DELEGATED HOUSEHOLDER DECISION

Item No. Report of the Head of Planning, Sport and Green Spaces**Address** 10 MILNE WAY HAREFIELD**Development:** Single storey side/rear extension**LBH Ref Nos:** **28426/APP/2015/4364****Drawing Nos:** 1799/12
1799/9
1799/10 Rev. A**Date Plans Received:** 27/11/2015**Date(s) of Amendment(s):****Date Application Valid:** 27/11/2015**1. CONSIDERATIONS****1.1 Site and Locality**

CLIENT:	MR & MRS GOSLING	DRG NO:	1799 10
PROJECT:	10 MILNE WAY HAREFIELD		
TITLE:	DETAIL PROPOSAL • SIDE EXTENSION FLOOR PLANS • ELEVATIONS • SECTIONS		
DATE:	OCT 2015	SCALE:	1:50 1:100 AT A1
DRAWN:

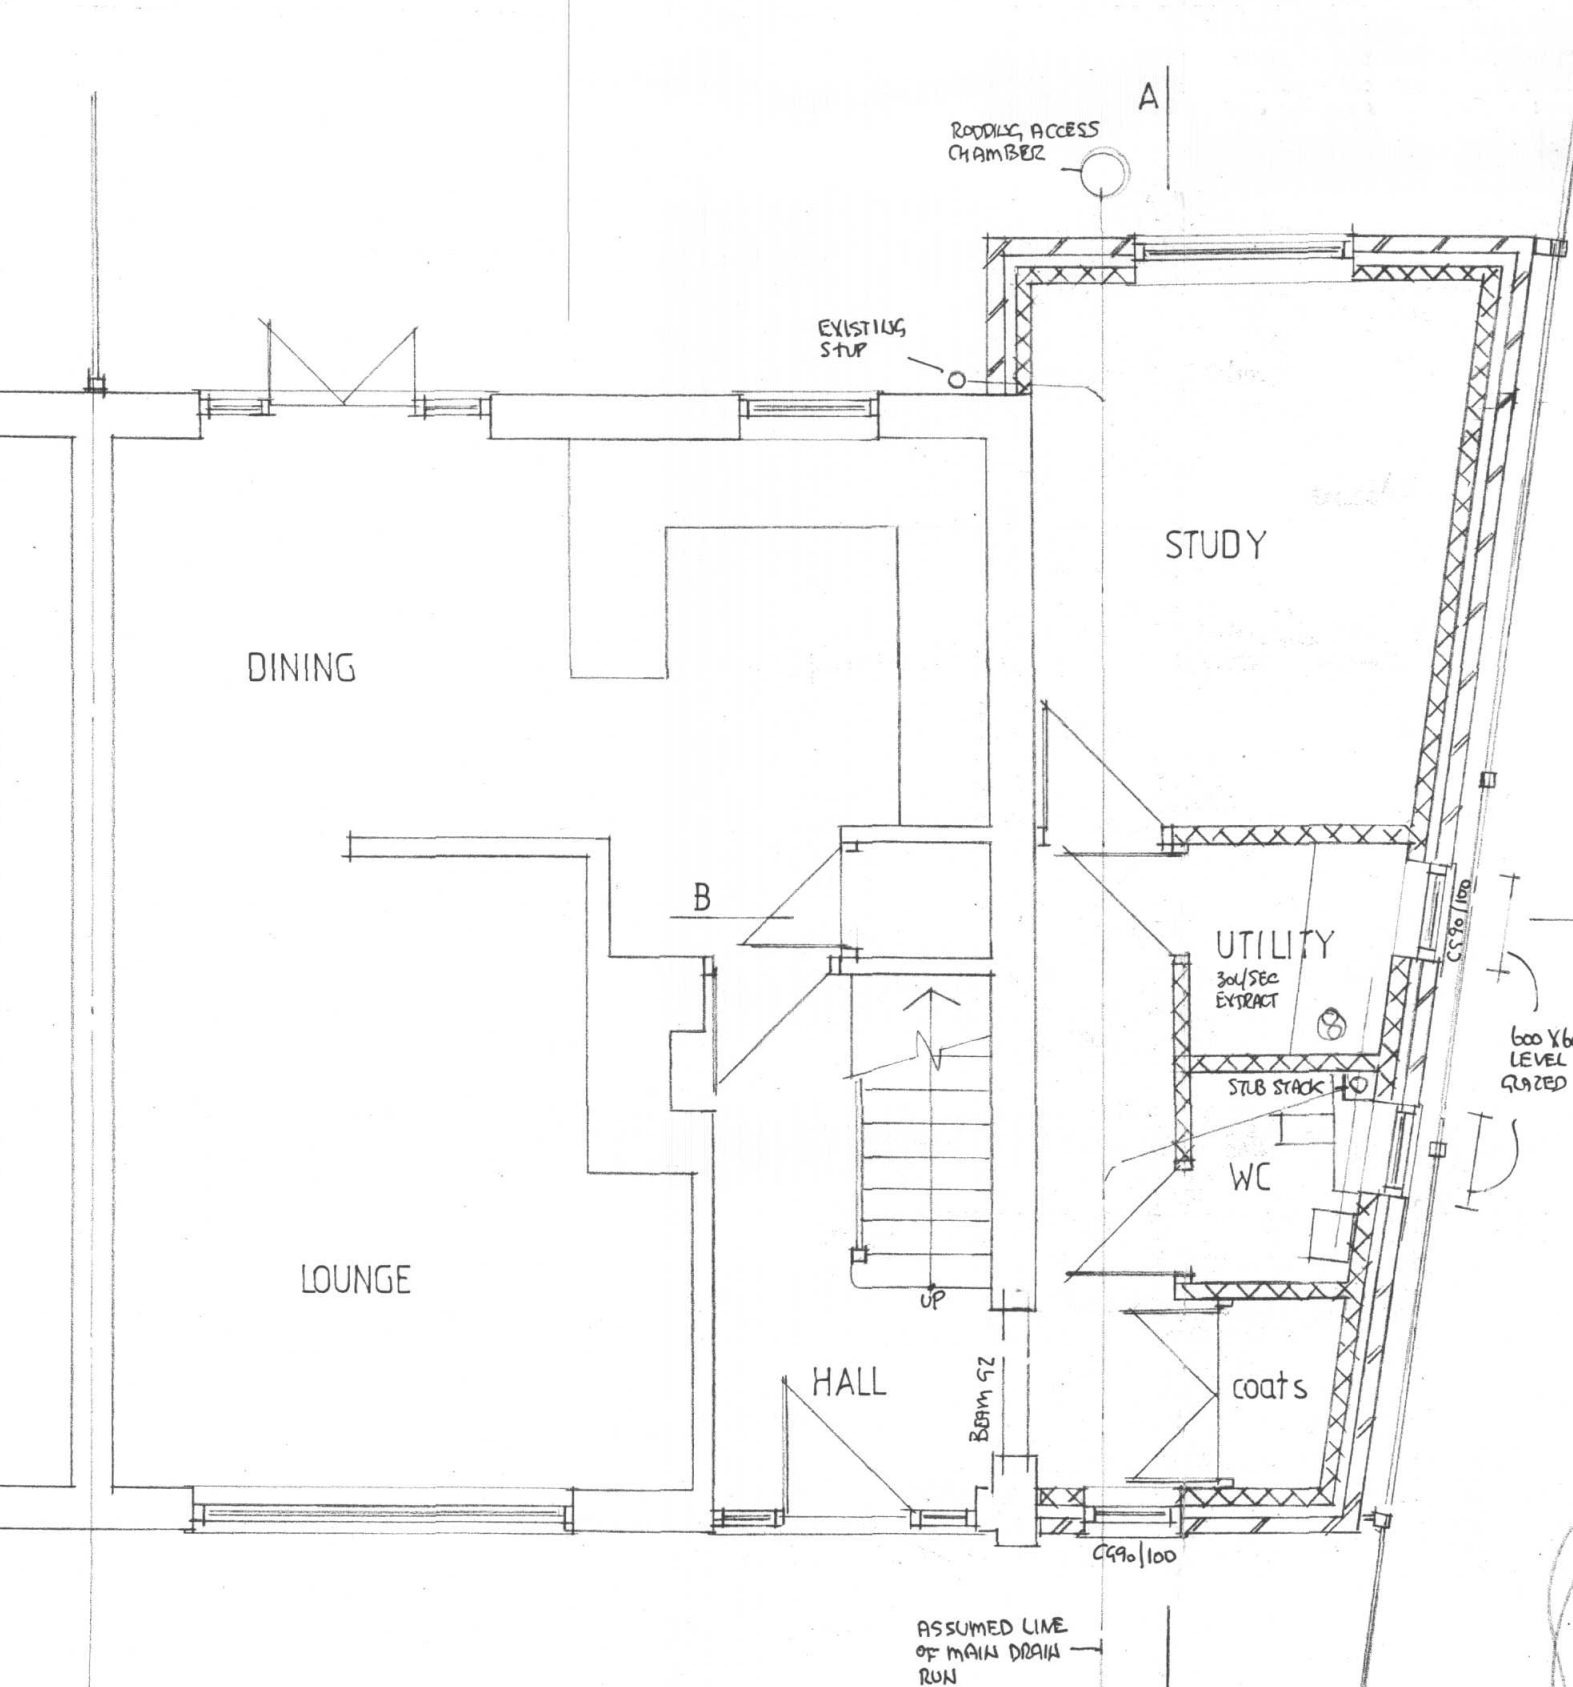
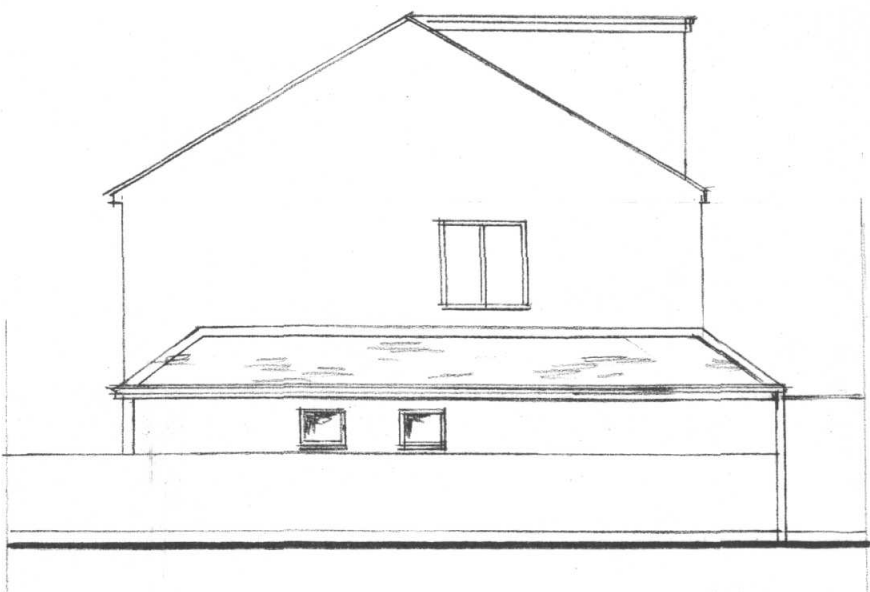
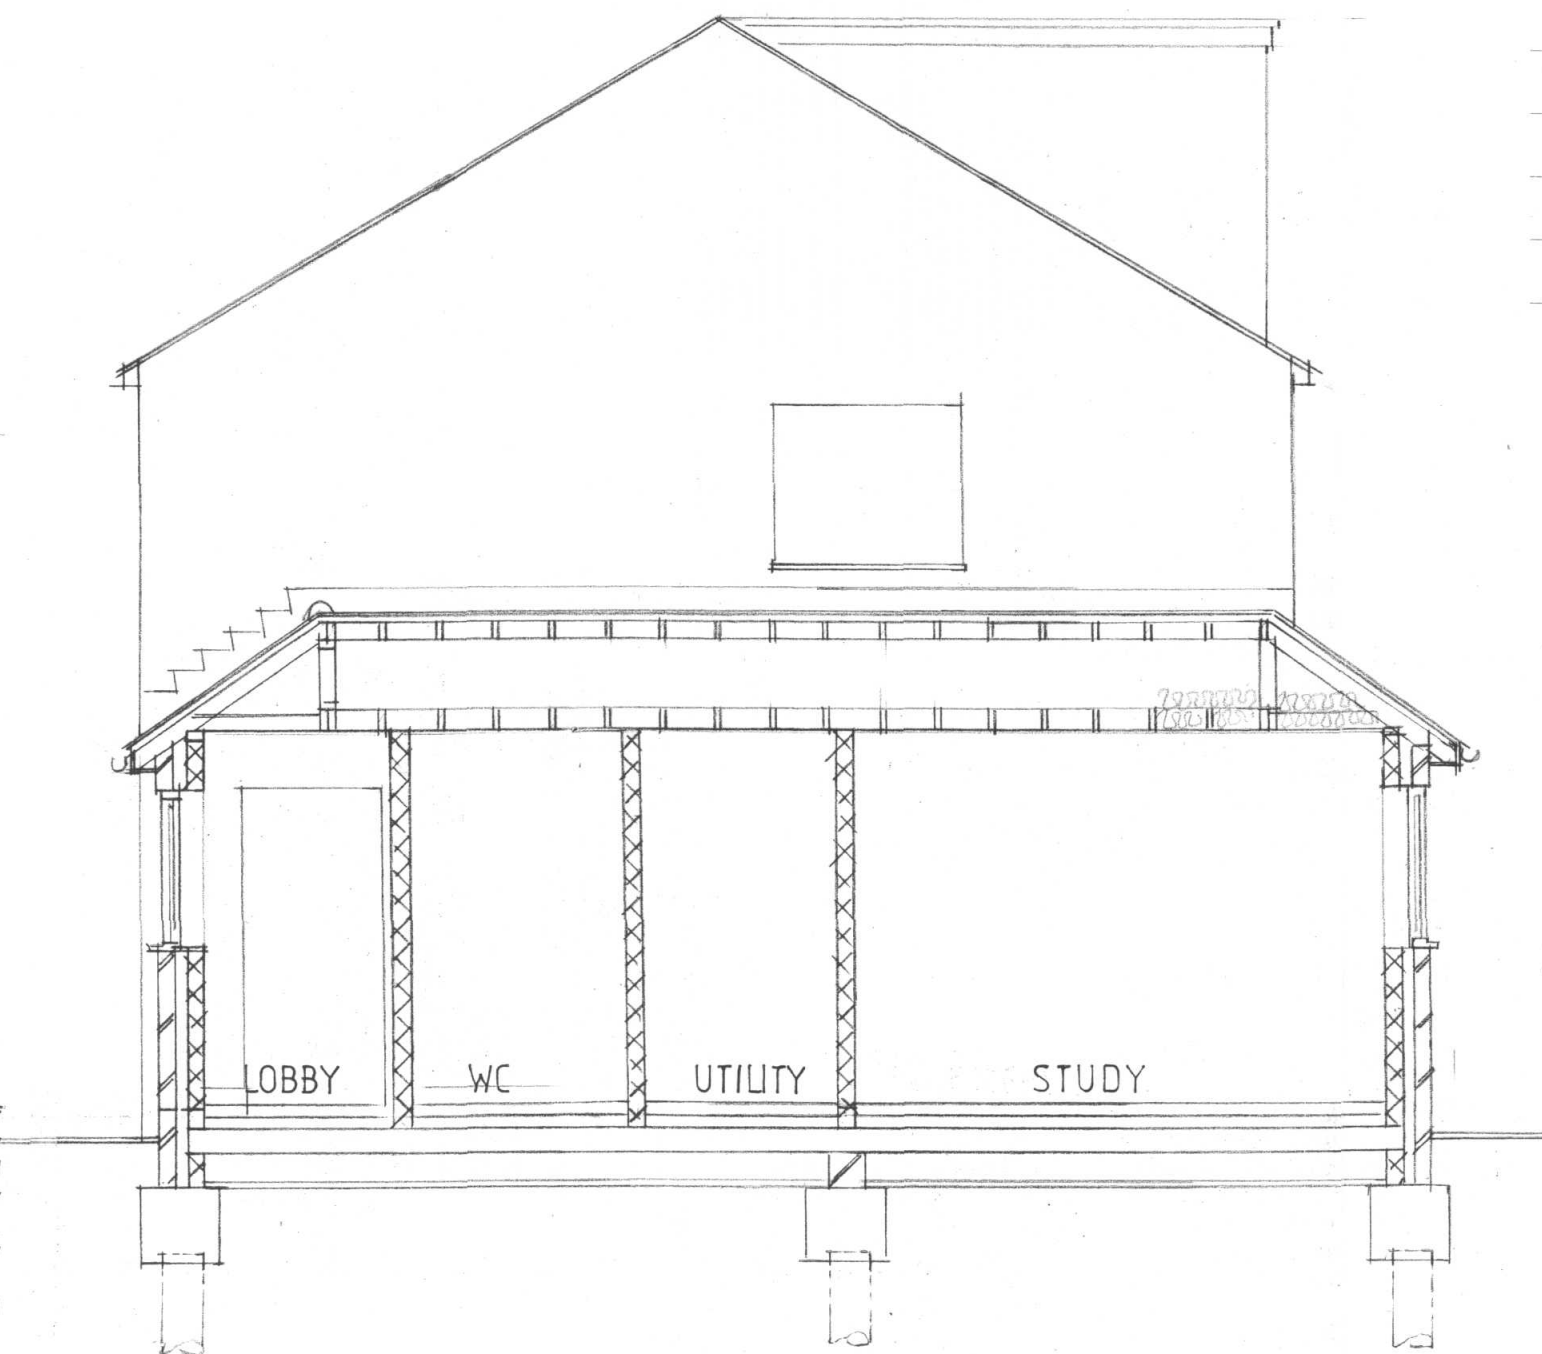
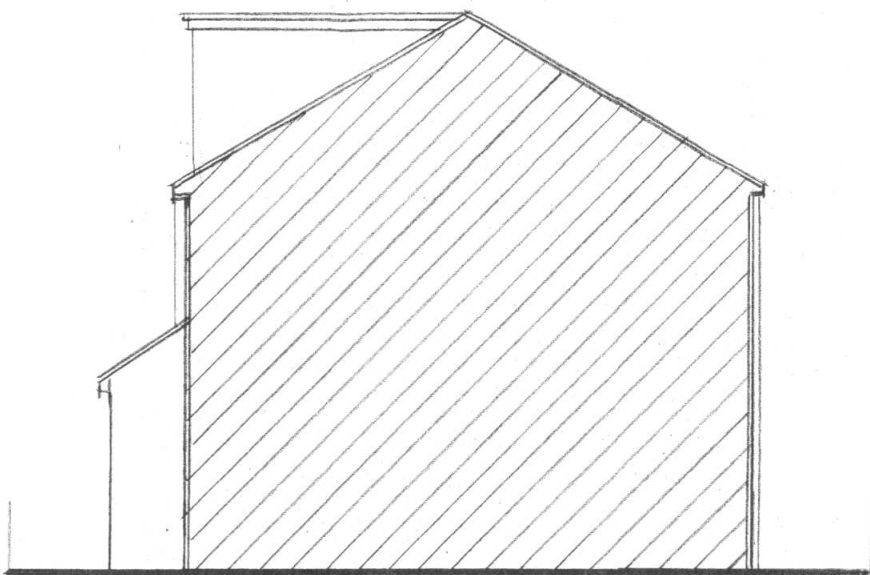
The proposed single storey side extension measures 8.55m in depth (the full depth of the existing property and extending 1m to the rear) and between 2.15m in width at the front widening to 3.65m to the rear, with a hipped roof detail of 3.4m in height (2.55m at the eaves). The extension follows the boundary line set in by 0.15m. The depth and height of the proposed single storey side/rear extension would be therefore be consistent with the requirements as set out in HDAS.

HDAS also advises that building lines within schemes should relate to the street pattern. The position of the proposed extension is in a prominent corner/end location on an estate where a degree of separation of properties to the boundaries on corner plots has been maintained. The feature of similar corner plots, are properties with a set back from the footway on the return road. The infilling of this characteristic open area right up to the boundary is therefore not considered acceptable in principle. Therefore, it is considered that the single storey side extension would detract from the visual amenities of the surrounding area and would not be in compliance with policies BE13, BE15 and BE19 of the Hillingdon Local Plan: Part Two - Saved Policies (November 2012) and section 4.0 of the Hillingdon Design & Accessibility Statement (HDAS): Residential Extensions.

The proposed single storey side/rear extension by reason of its size, scale, height, length of projection and siting in this open prominent position, would result in the loss of the open and spacious appearance of this prominent corner site, and would result in a cramped appearance. The proposal would therefore represent an overdevelopment of the site to the detriment of the character and visual amenities of the area and to this existing open area of the street scene. Therefore the proposal is contrary to Policy BE1 of the Hillingdon Local Plan: Part One - Strategic Policies (November 2012), Policies BE13, BE15 and BE19 of the Hillingdon Local Plan: Part Two - Saved UDP Policies (November 2012) and the adopted Supplementary Planning Document HDAS: Residential Extensions.
